From: Paul Cann
Sent: 26 October 2017 15:34
To: Planning.Responses
Subject: RE: Planning Consultation on: WA/73/17/OUT

Engineers comments in respect to surface water drainage:

APPLICATION NO: WA/73/17/OUT

Site Address: Land East of Wandleys Lane and West of West Walberton
Lane Fontwell

PBA drawing 40523/4001/001 Revision A – Proposed Outline Surface Water Drainage Strategy

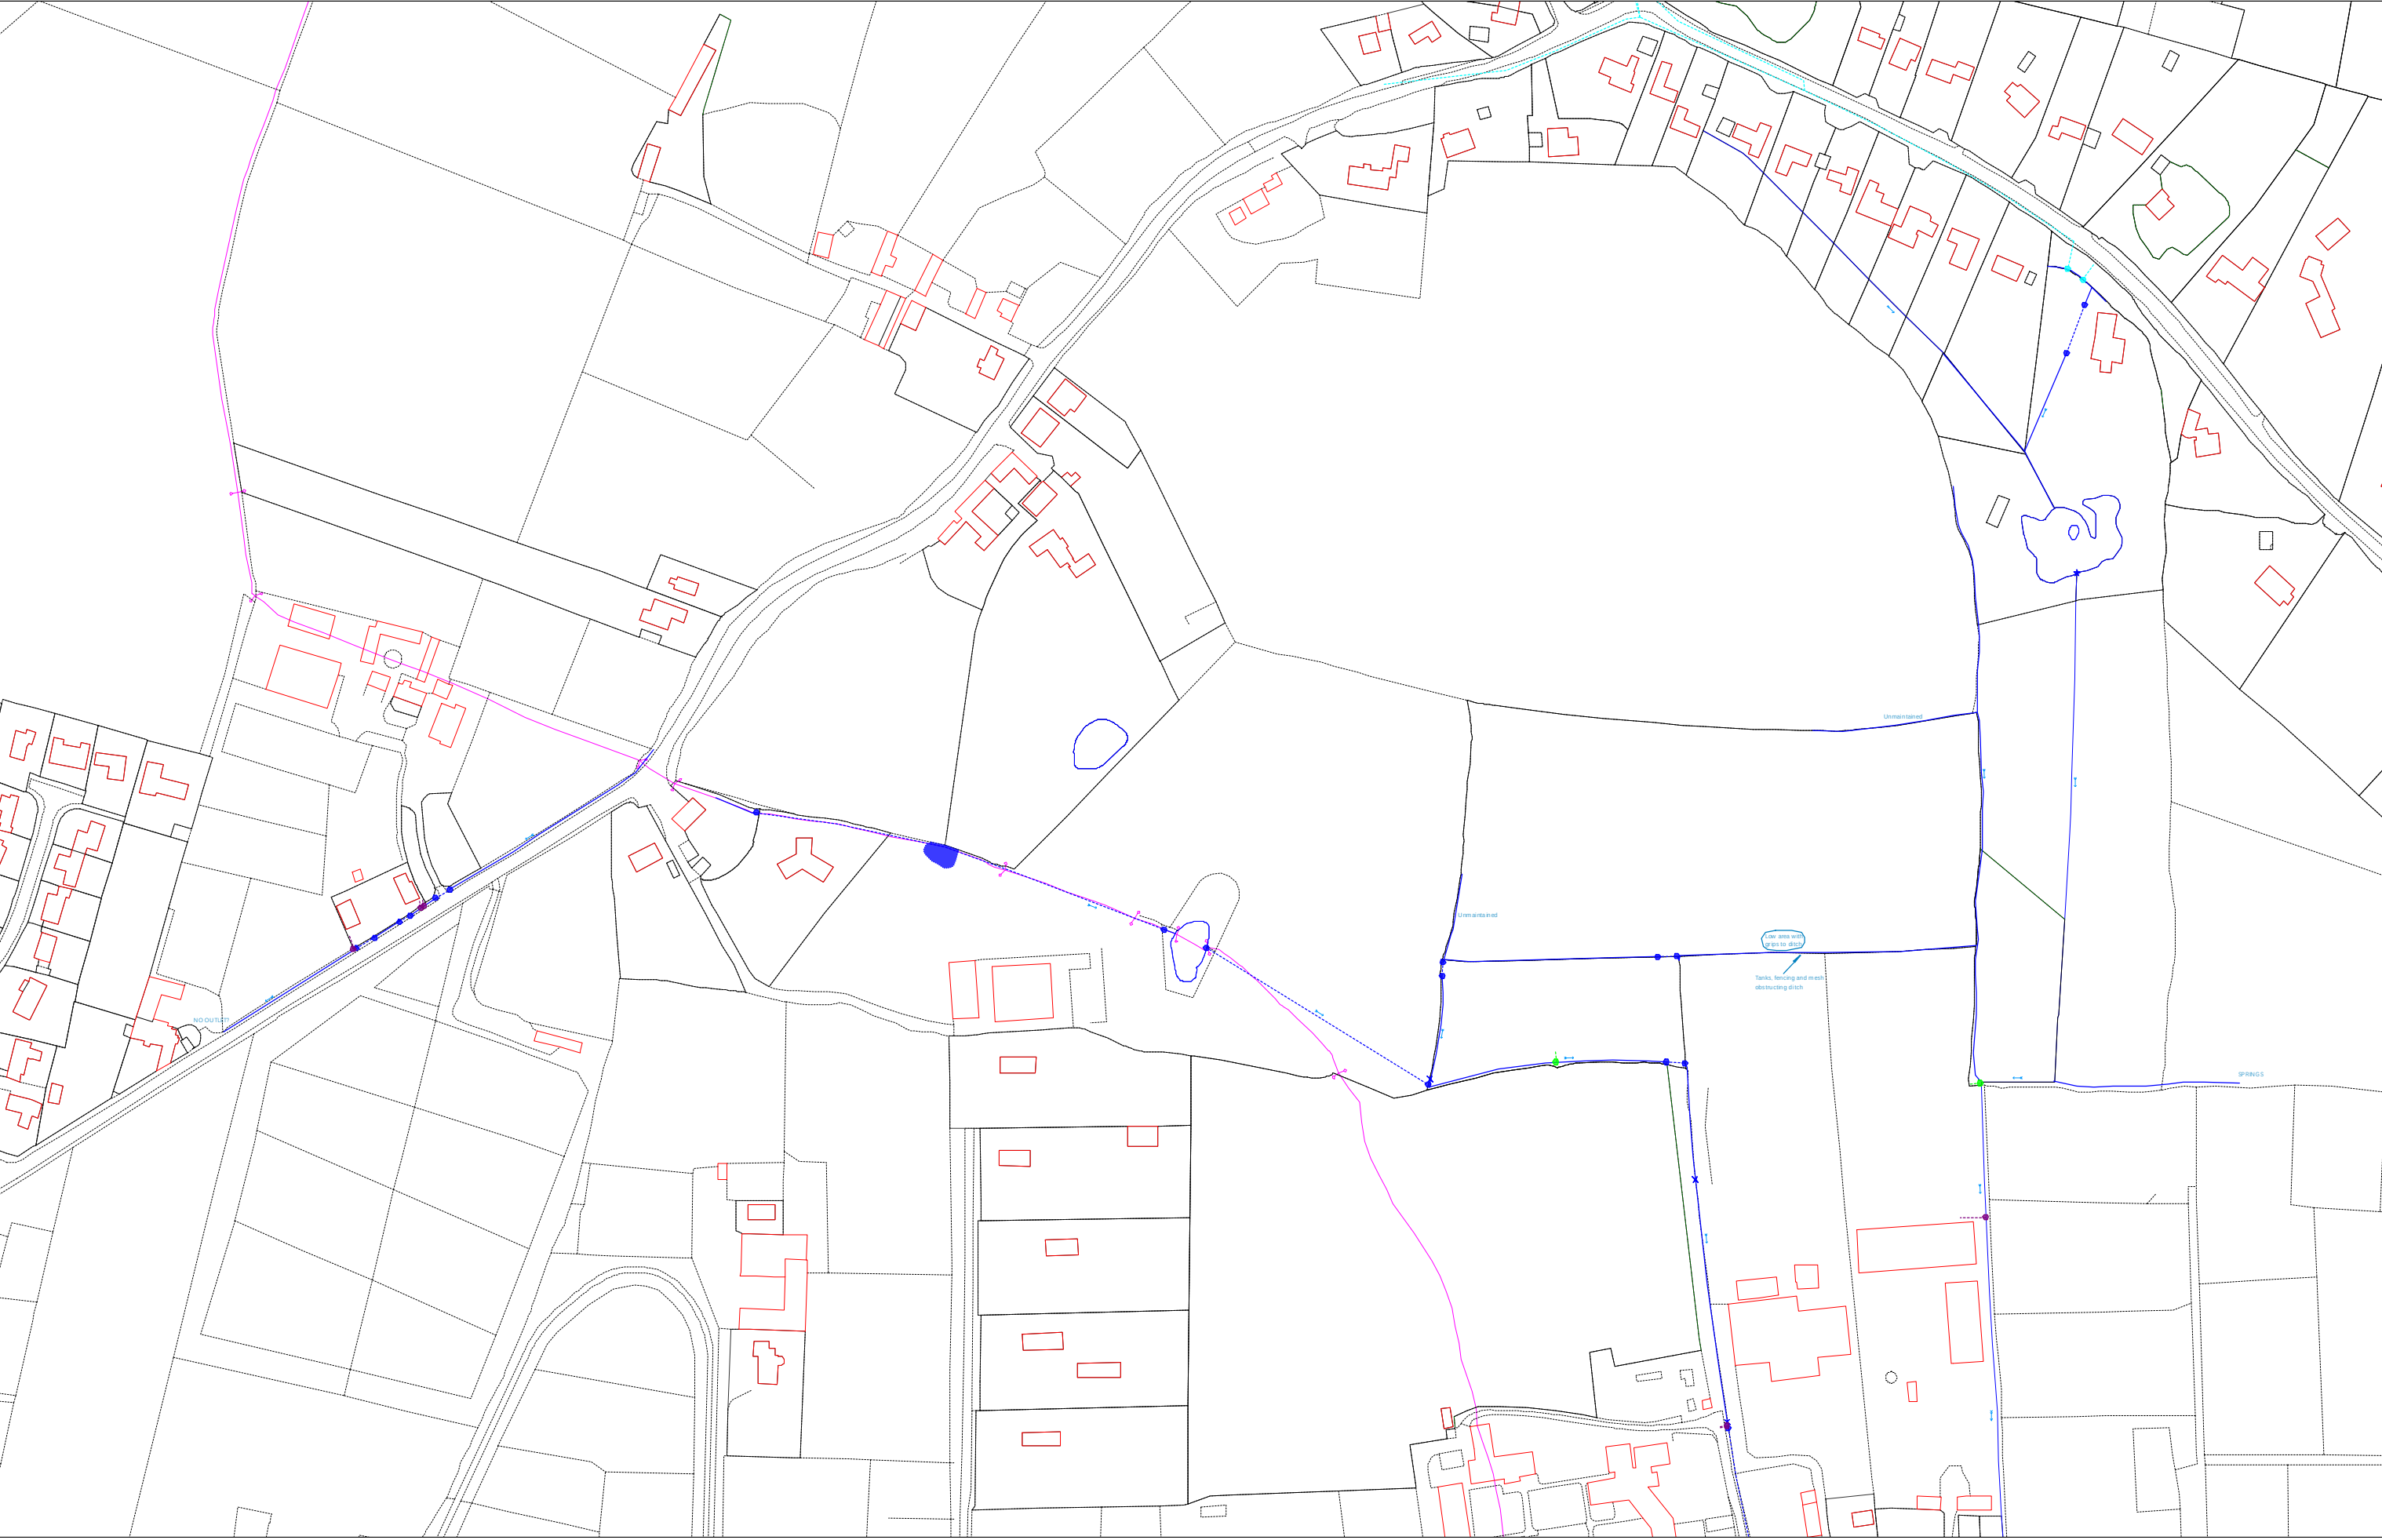
It is appreciated that the site is likely to be subjected to a high water table, however, the use of infiltration structures must be fully investigated before being dismissed. Although, a connection to the existing watercourse will almost certainly be required, shallow infiltration must be considered if possible and could be incorporated into a hybrid scheme if achievable. In order for this to be determined, further investigations will be required and will need to comprise of winter groundwater monitoring to identify peak levels and winter percolation testing at agreed depths.

Infiltration rates for soakage structures are to be based on percolation tests undertaken in the winter period and at the location and depth of the proposed structures. The percolation tests must be carried out in accordance with BRE 365, CIRIA R156 or a similar approved method and cater for the 1 in 10 year storm between the invert of the entry pipe to the soakaway, and the base of the structure. It must also have provision to ensure that there is capacity in the system to contain below ground level the 1 in 100 year event plus 30% on stored volumes, as an allowance for climate change. Adequate freeboard must be provided between the base of the soakaway structure and the highest recorded annual groundwater level identified in that location. Supplementary guidance notes are also enclosed for information.

Achieving betterment in terms of greenfield runoff rates to the watercourse should also be a consideration.
